# CITY OF ALBUQUERQUE

**Re: Azar-Menaul Townhomes, Grading and Drainage Plan  
Engineer's Stamp Date 5/17/2015 (H22/D078)**

**Subject:** FW: Indian Ridge Subd.

Rudy, Please find the responses to your written comments dated 5/12/16. The initial comments area in black and our response as to how we addressed are in blue:

ENGINEER'S SEAL 	TRACT 2-A INDIAN RIDGE SUBDIVISION	DRAWN BY JDG
	GRADING AND DRAINAGE PLAN	DATE 11-16-2015
	 Rio Grande Engineering 1606 CENTRAL AVENUE SE SUITE 201 ALBUQUERQUE, NM 87106 (505) 872-0999	SHEET # DRB 03
		JOB #

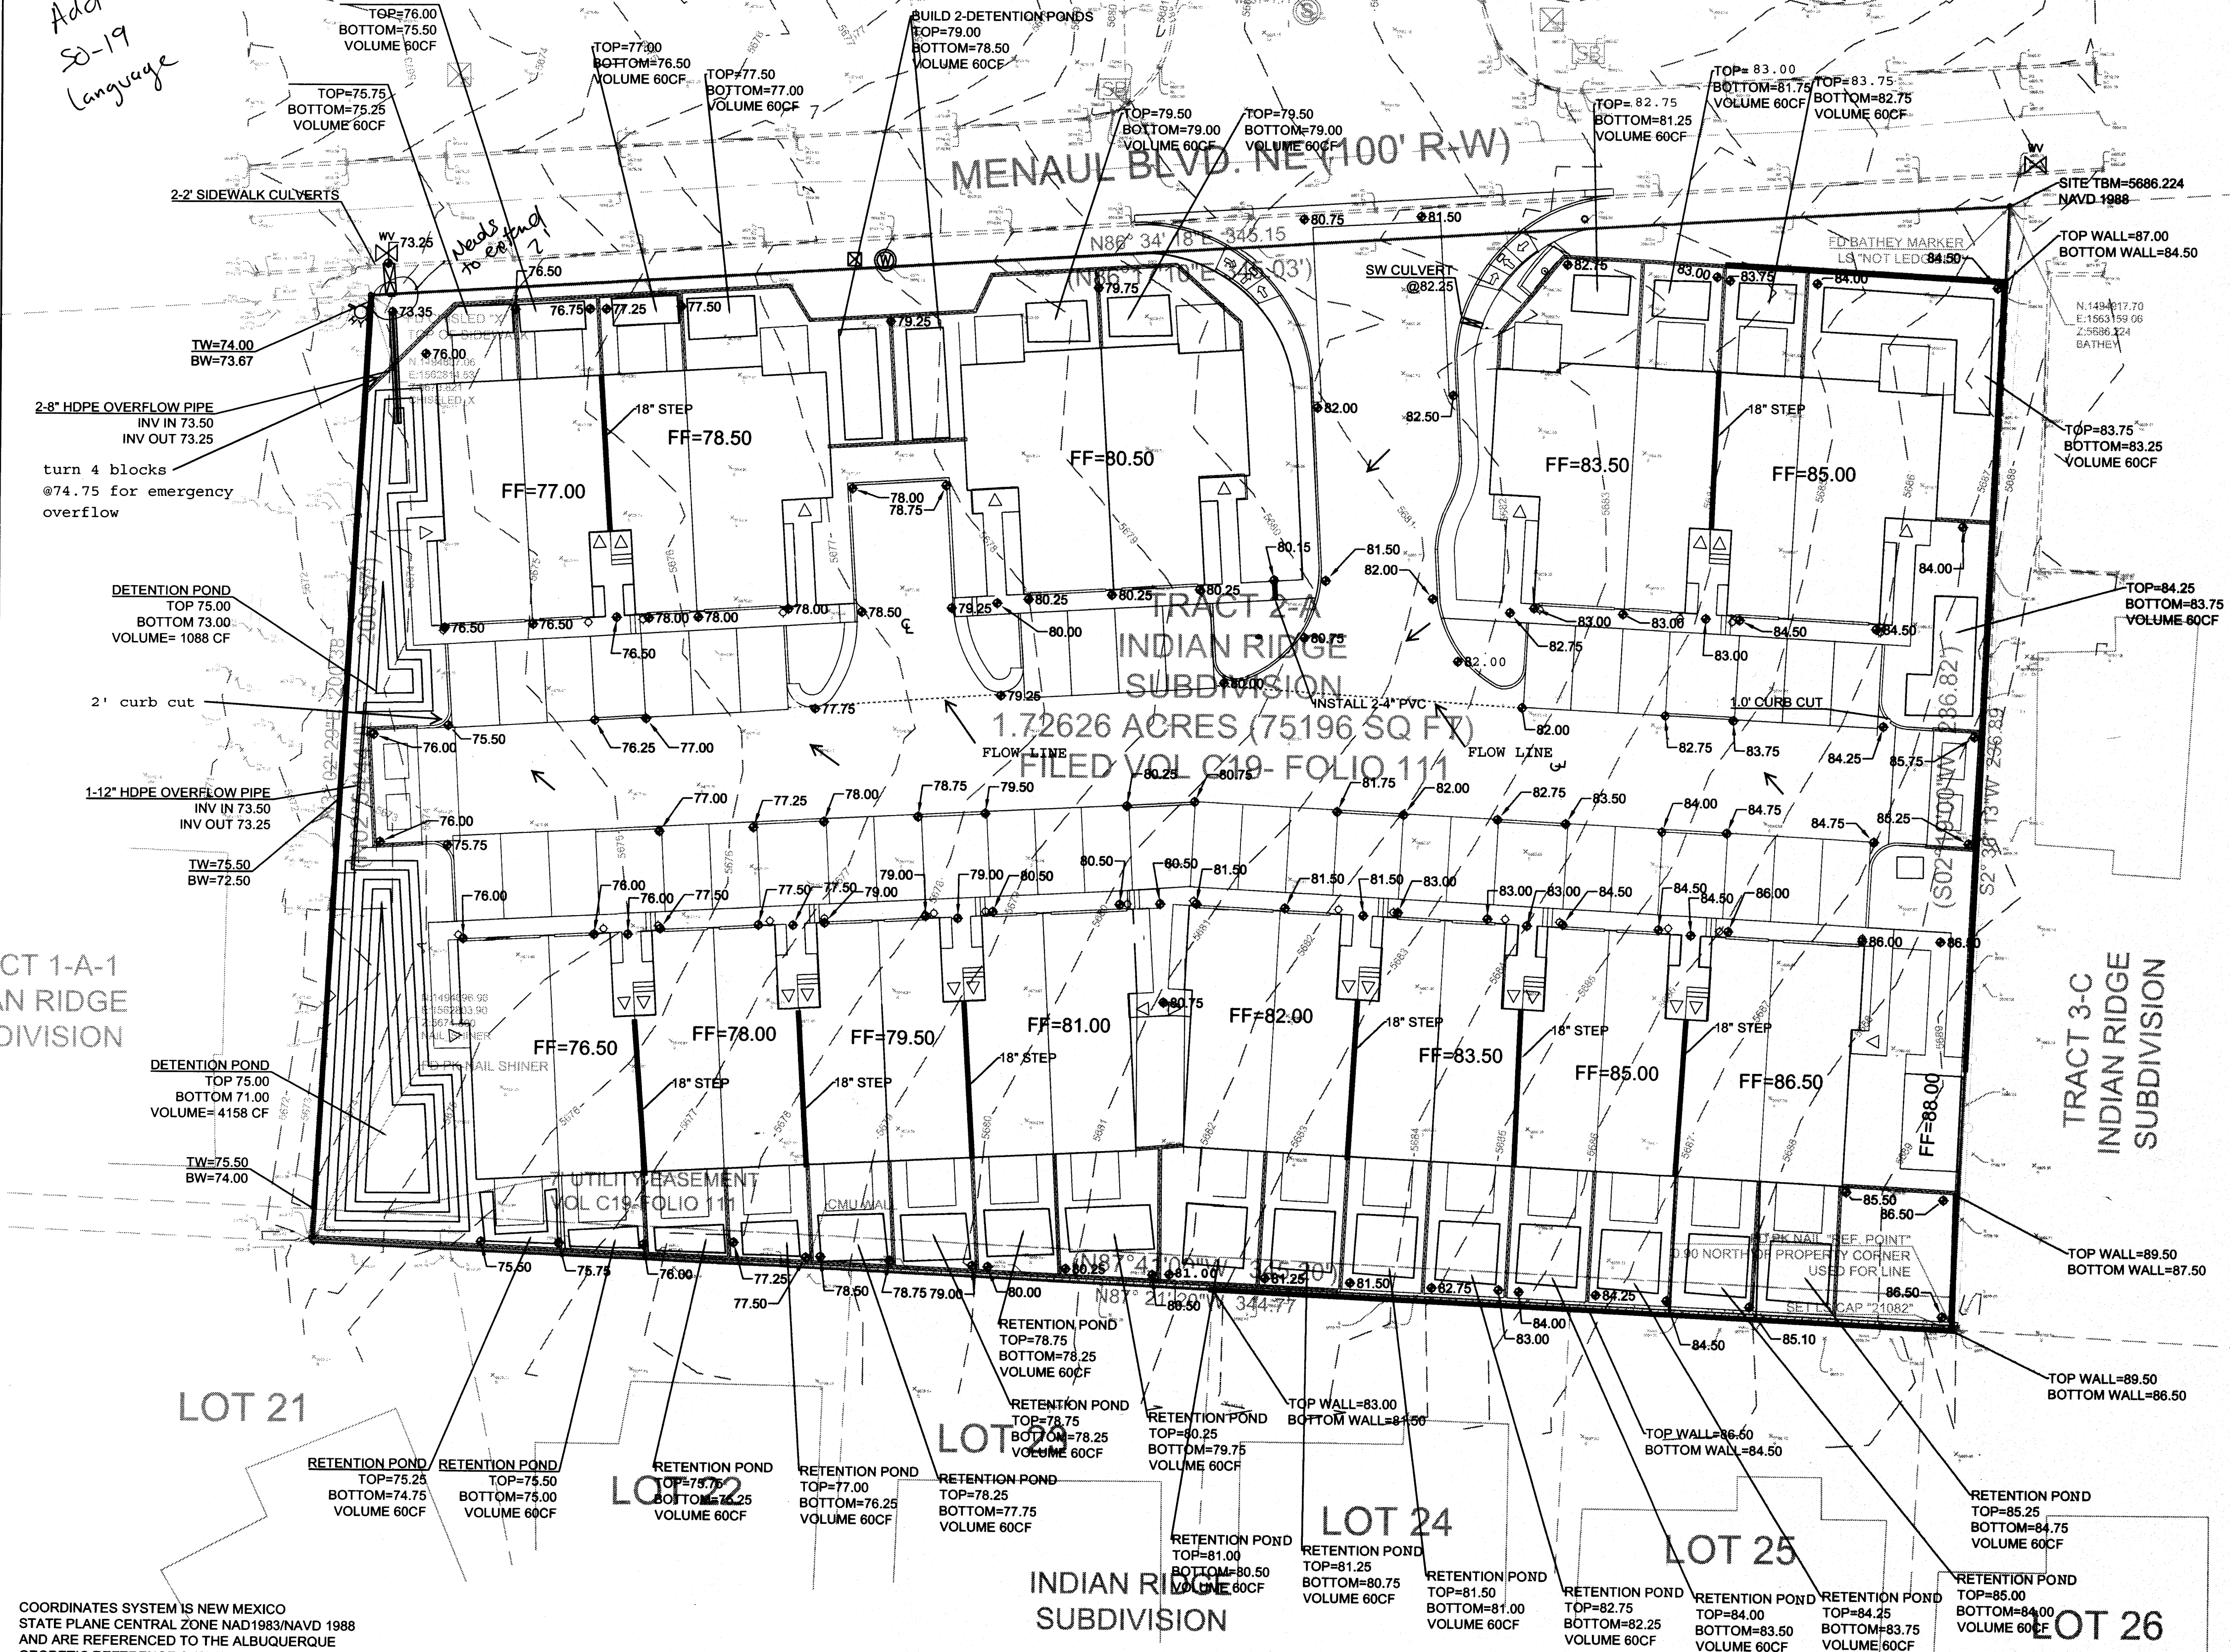
- There are some darkened lines throughout the site, are these all retaining walls?  
**YES, I HAVE ADDED LABELS TO CLARIFY, WE HAVE TOP AND BOTTOMS CALLED OUT**

- Provide a detail for all retaining walls.  
**I HAVE ATTACHED, THESE ARE PART OF SEPARATE PERMIT**
- How will flows leave the back yards? Provide turn blocks 3" above grade.

**WE HAVE ADDED TO NOTE TO PLAN AND ADDED TO NOTE#3**
- Provide a detail where the block wall and the 8" HDPE intersect each other.  
**I HAVE ADDED NOTE TO PLAN TO CLARIFY THE PIPE RUNS UNDER WALL  
BOTTOM OF WALL=75.00, TOP OF PIPE=74.00**

- Provide elevations around the exterior of the perimeter.  
**I HAVE ADDED**
- Show roof flows.  
**THE ROOFS ARE PITCH SO I HAVE ADDED ROOF DRAIN PATTERN ON SE BUILDING  
AND LABELED AS  
TYPICAL**

- Provide a note requiring a separate permit for all walls is required.  
**I HAVE ADDED AS NOTE#4**
- Show the extension of the sidewalk culvert 2 feet passed the property line.

**I HAVE CORRECTED THE DRAWING TO BE GRAPHICALLY CORRECT**
- The NW corner of the sites spot elevation is higher than the invert out, please correct.  
**WE HAVE CORRECTED THIS TYPO.**
